Sedona Sun Acres Stormwater Drainage Study

Colorado Springs, El Paso County, Colorado

March, 2020

DRAINAGE MAPS

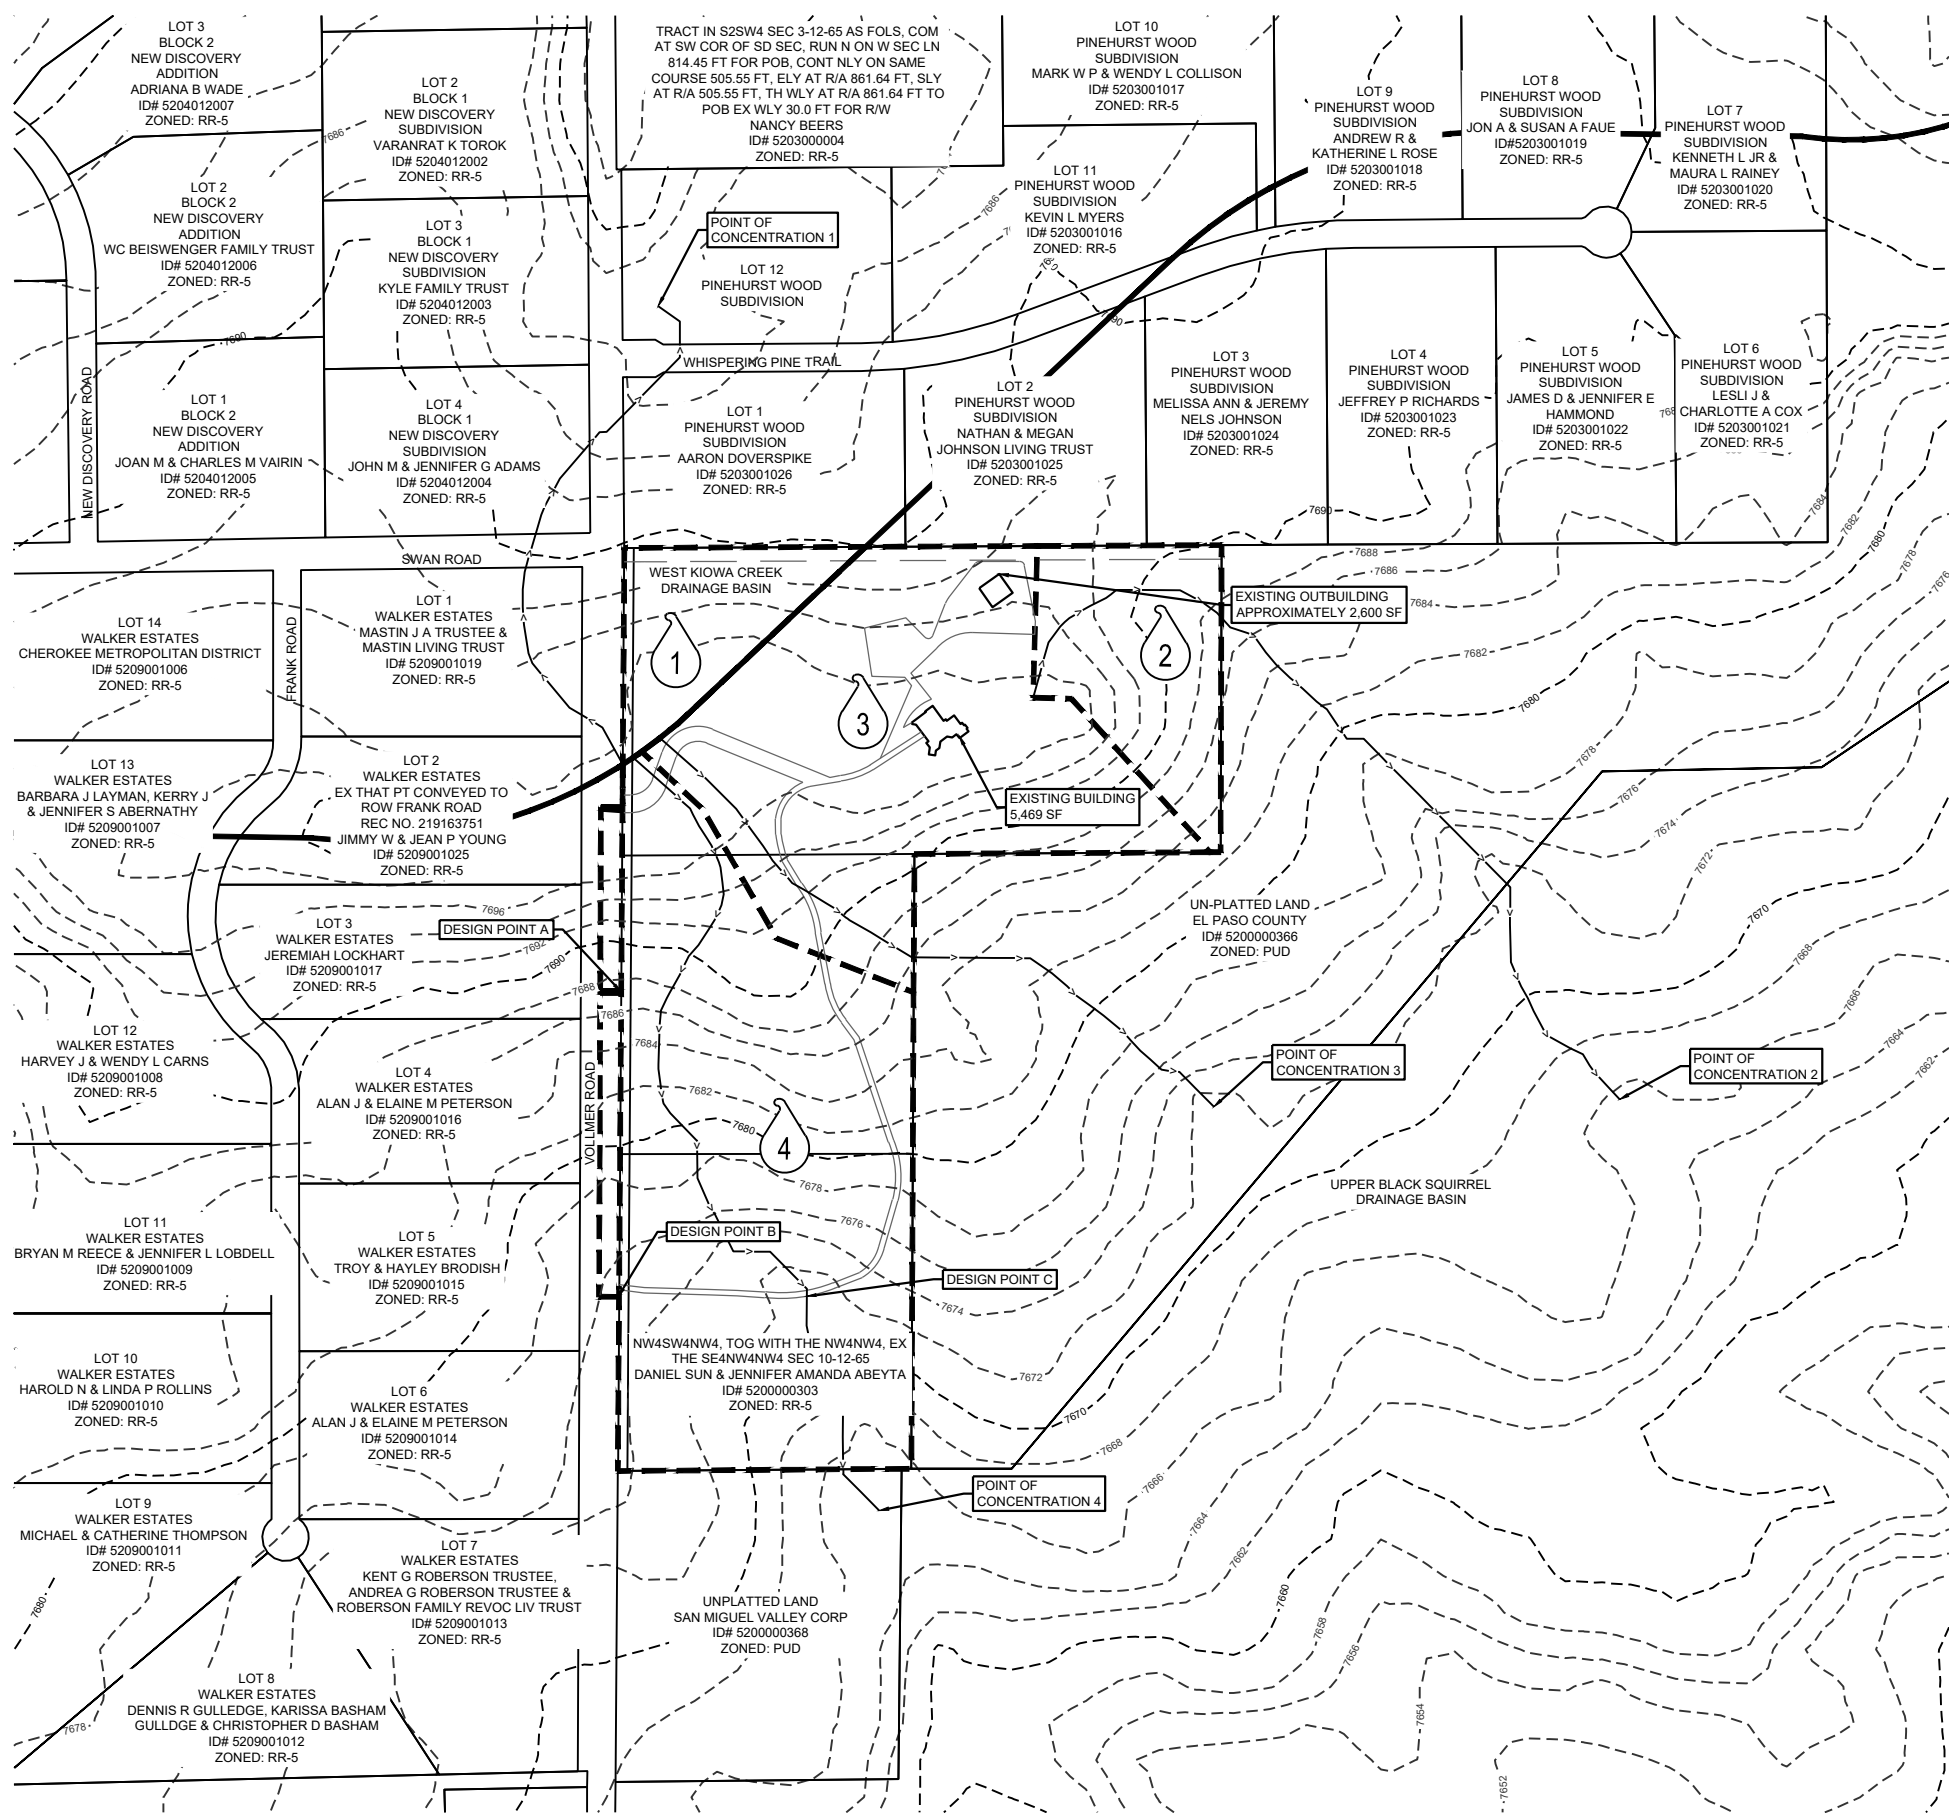
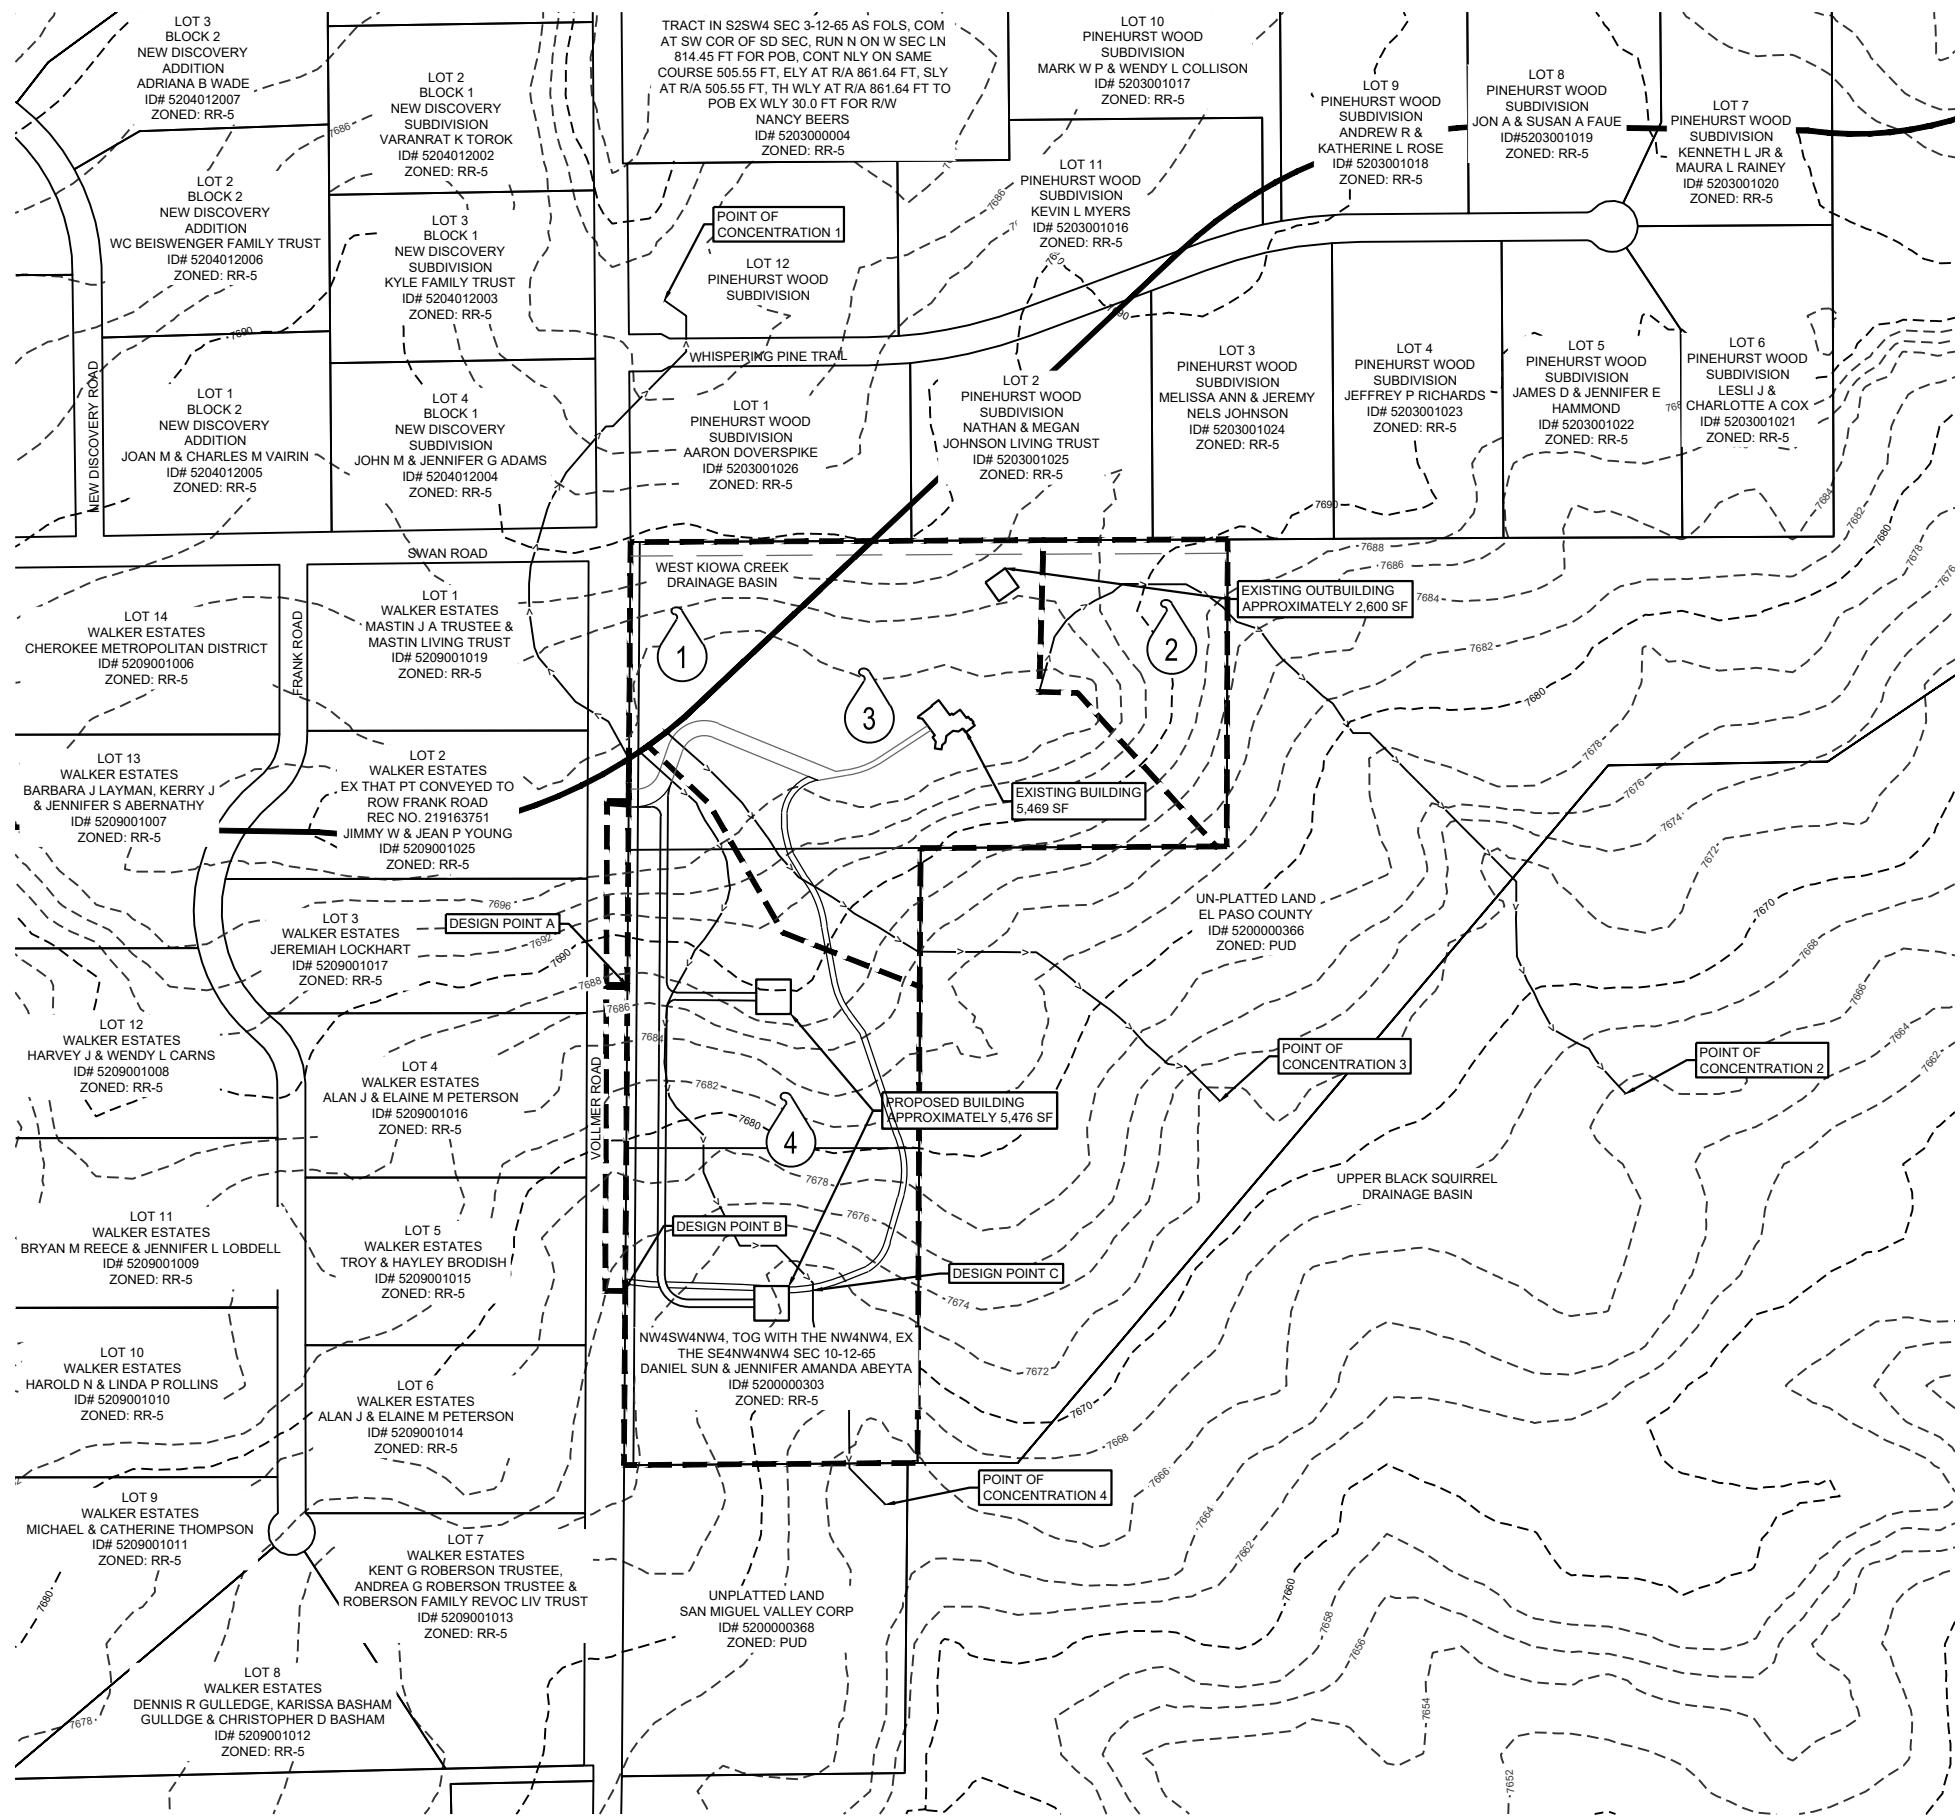
- 1) Move drainage maps to the end of the document for review purposes.
- 2) Include maps to include the existing and proposed conditions per the Drainage Criteria Manual Vol. I, Section I, Chapter 4.5 Small Subdivision Drainage Report Format:
 - (a) general existing drainage characteristics (on and off site)
 - (b) general proposed drainage characteristics (on and off site)
